One Earth Solar Farm

**Draft Statement of Common Ground with Newark and
Sherwood District Council**

EN010159/APP/8.6

July 2025

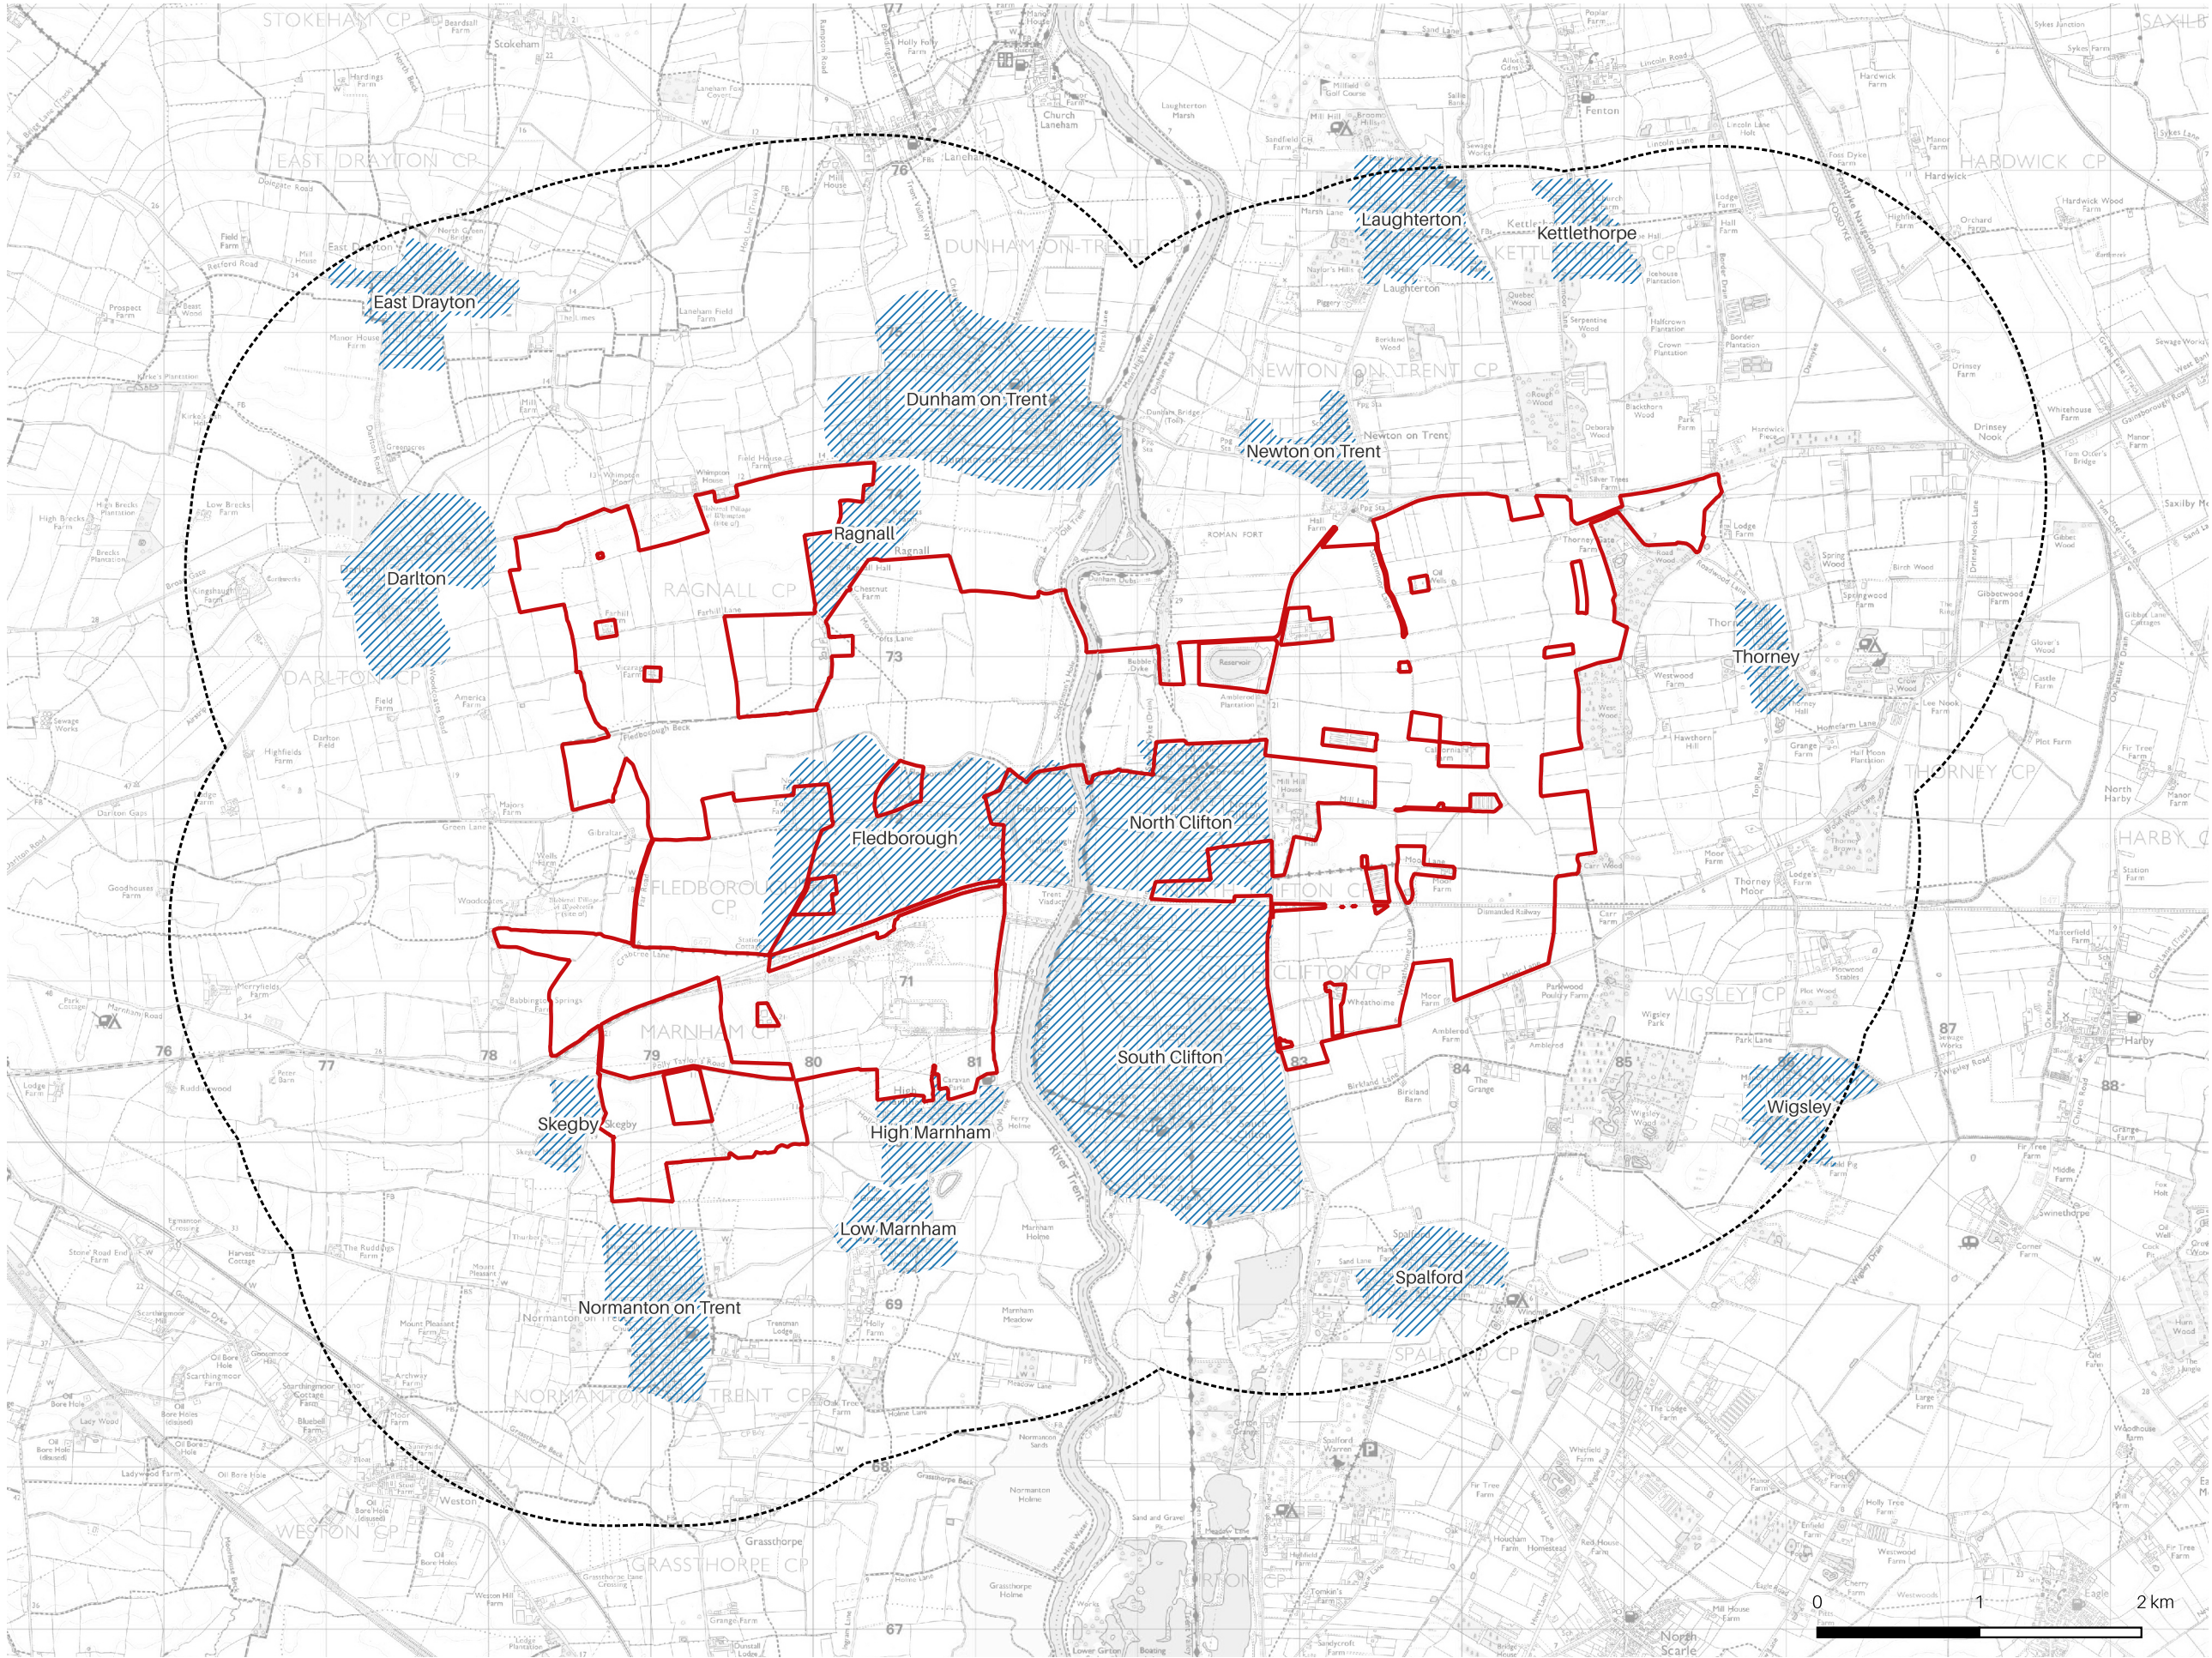
04-03	Scope of landscape receptors	The inclusion of Thorney as a Local Village Character Area following feedback on the PEIR was welcomed. No further comments or concerns on the	The scope of landscape receptors is agreed. The scope of landscape receptors was updated in the LVIA ES Chapter to include for the suggested additions and refinements.	Agreed

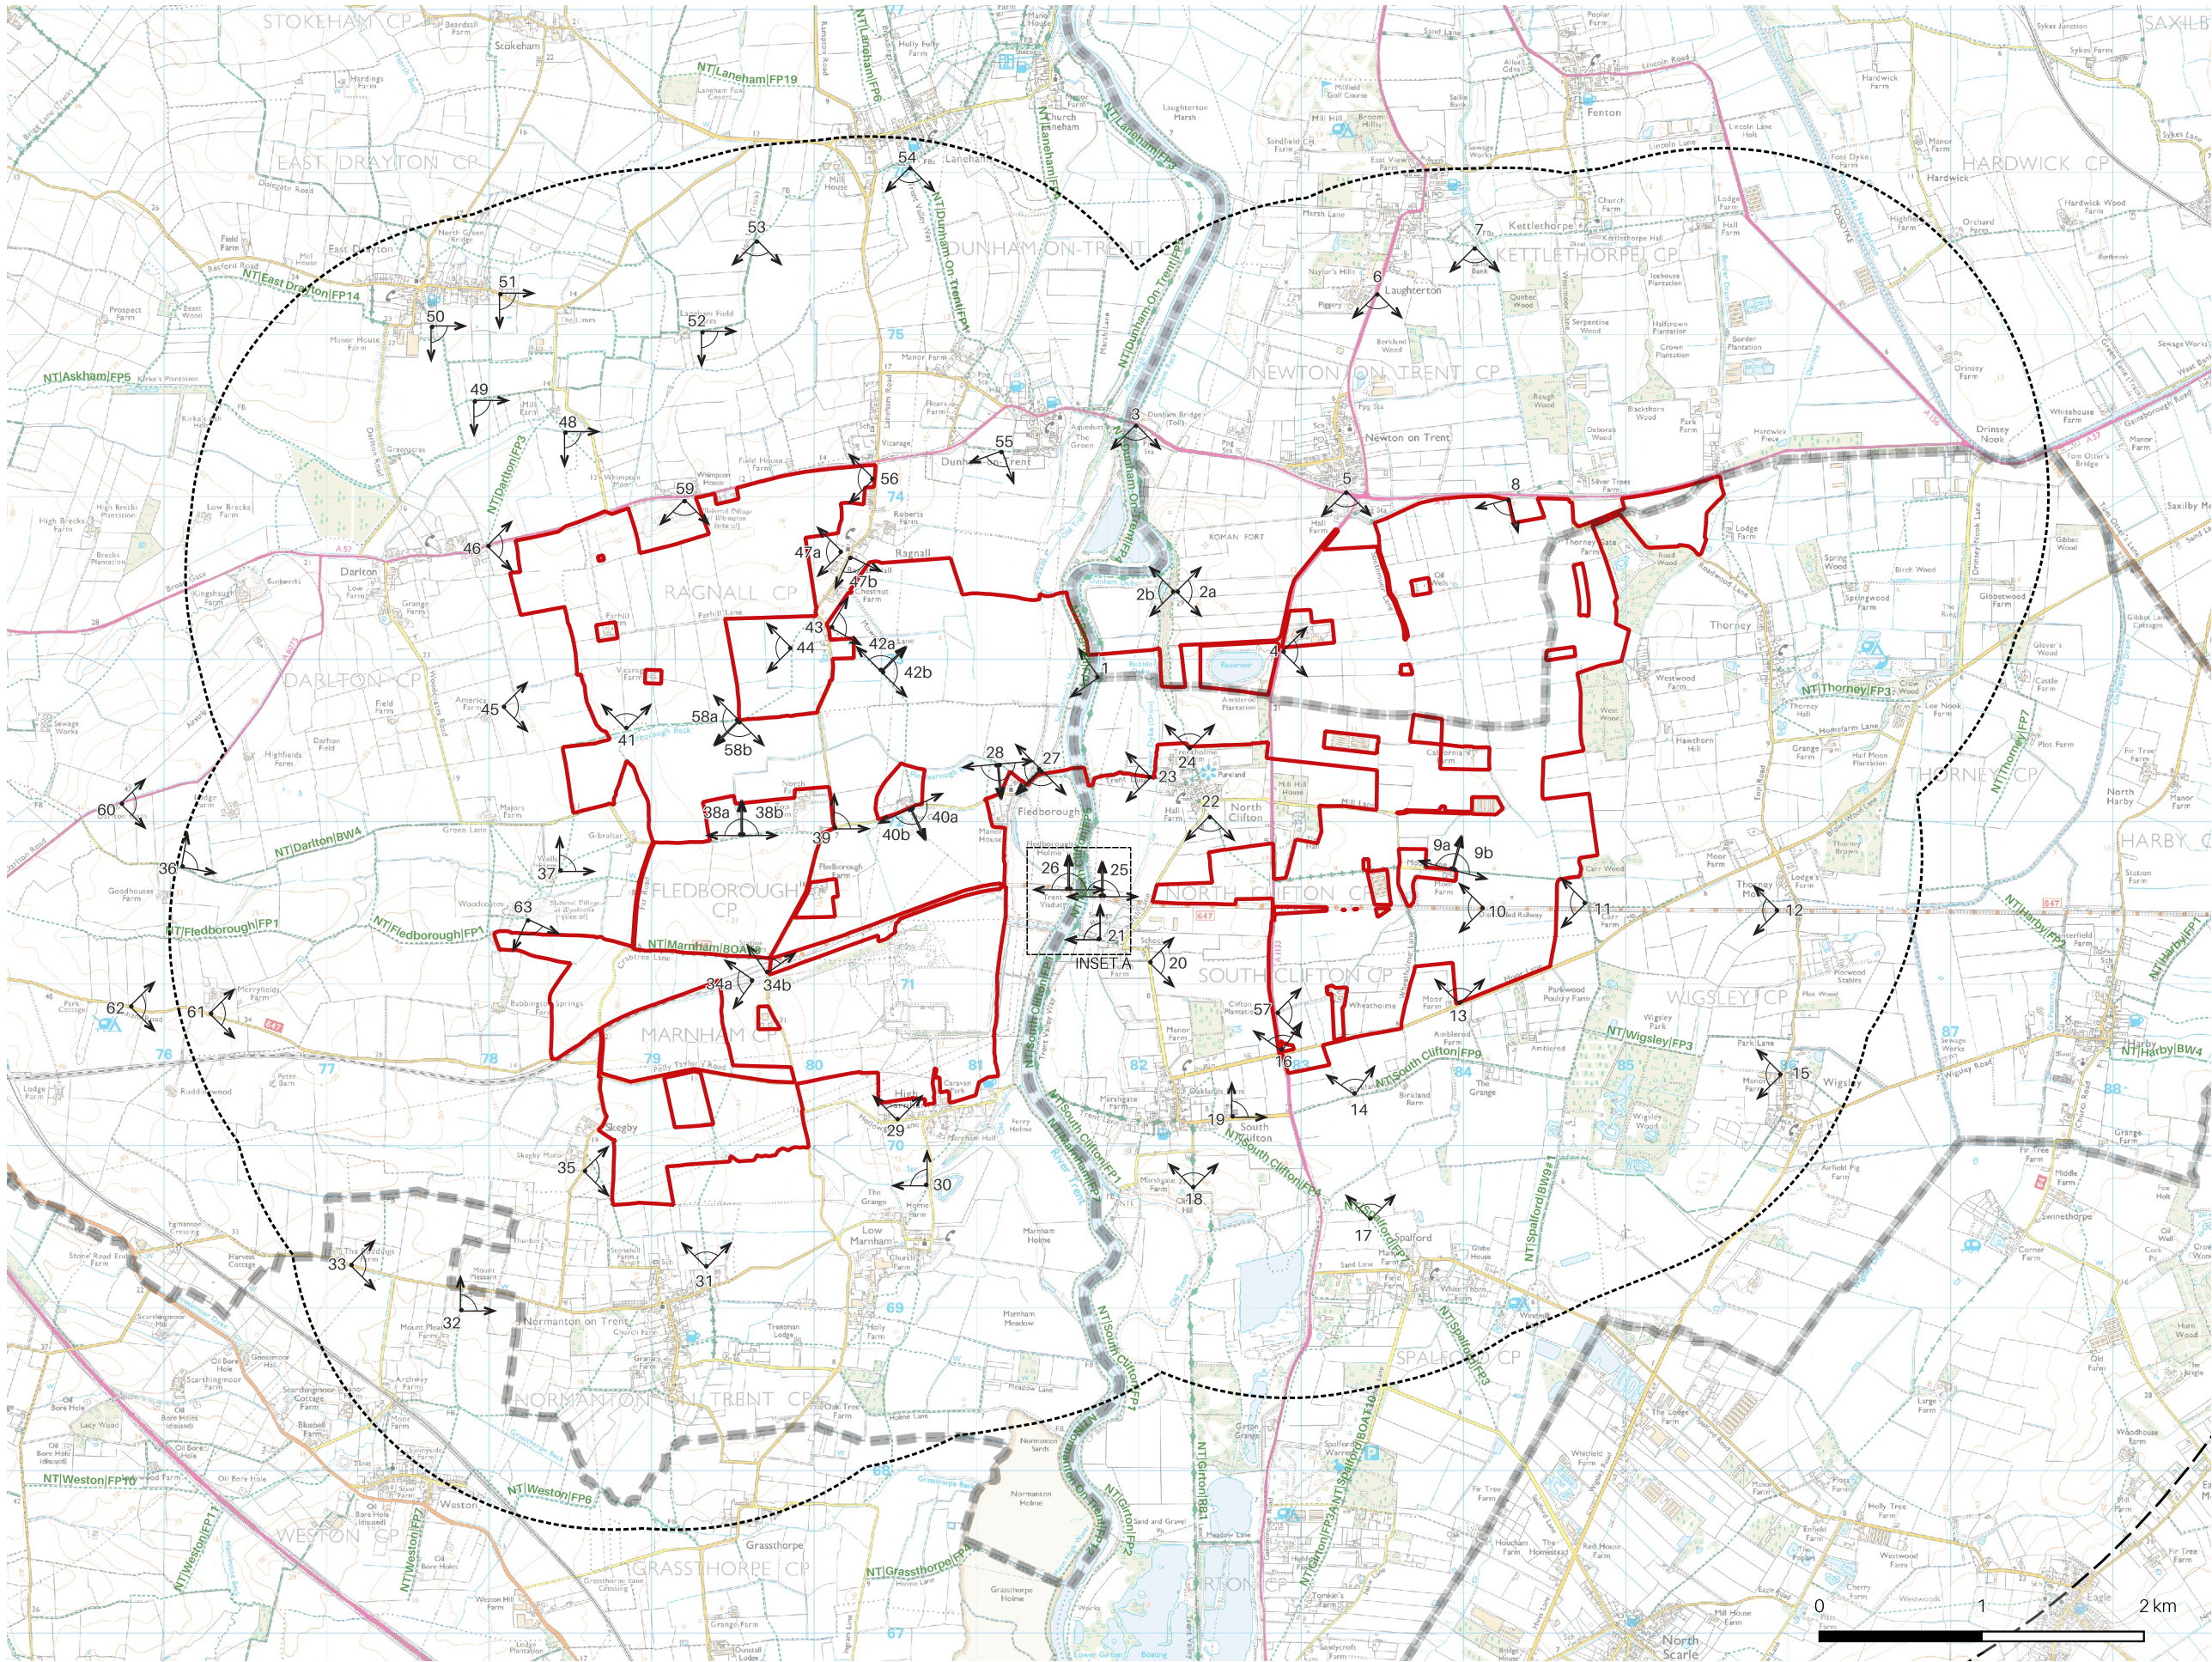
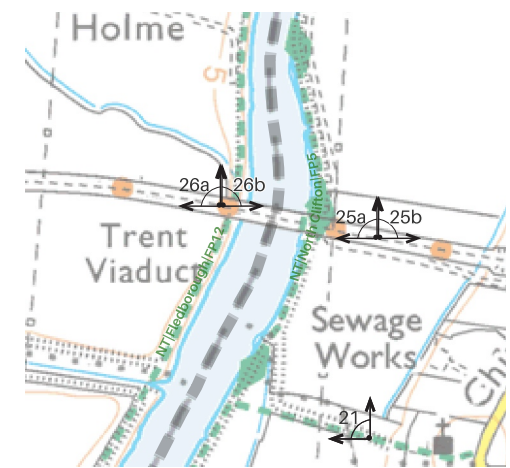
- Acknowledgement of improved ZTV analysis and fieldwork
- Acceptance of revised LVIA methodology as best practice
- Critique of viewpoint selection beyond 2km (suggested better locations)
- Request for more strategic viewpoint placement at submission stage

scope of landscape receptors have been raised to date.		
04-04	Scope of visual receptors	Additional visual receptors were suggested following review of the PEIR. No further comments or concerns on the scope of visual receptors have been raised to date.	The scope of visual receptors is agreed. The scope of visual receptors was updated in the LVIA ES Chapter to include for the suggested additions and refinements.	Agreed
04-05	Scope of representative viewpoints	The location of some of the representative viewpoints were questioned and additional viewpoints were suggested following review of the PEIR. No further comments or concerns on the scope of representative viewpoints have been raised.	The scope of representative viewpoints is agreed. The scope of representative viewpoints was updated in the LVIA ES Chapter to include for the suggested additions and refinements.	Agreed
04-06	Scope of photomontages	An additional Type 4 photomontage was suggested from Viewpoint 58 following review of the PEIR. No further comments or concerns on the scope of representative viewpoints have been raised.	The scope of photomontages is agreed. Further discussion was had between the applicant and the District Councils during the preparation of the LVIA ES Chapter regarding the scope of photomontages resulting in agreement that the number and distribution of locations is sufficient.	Agreed
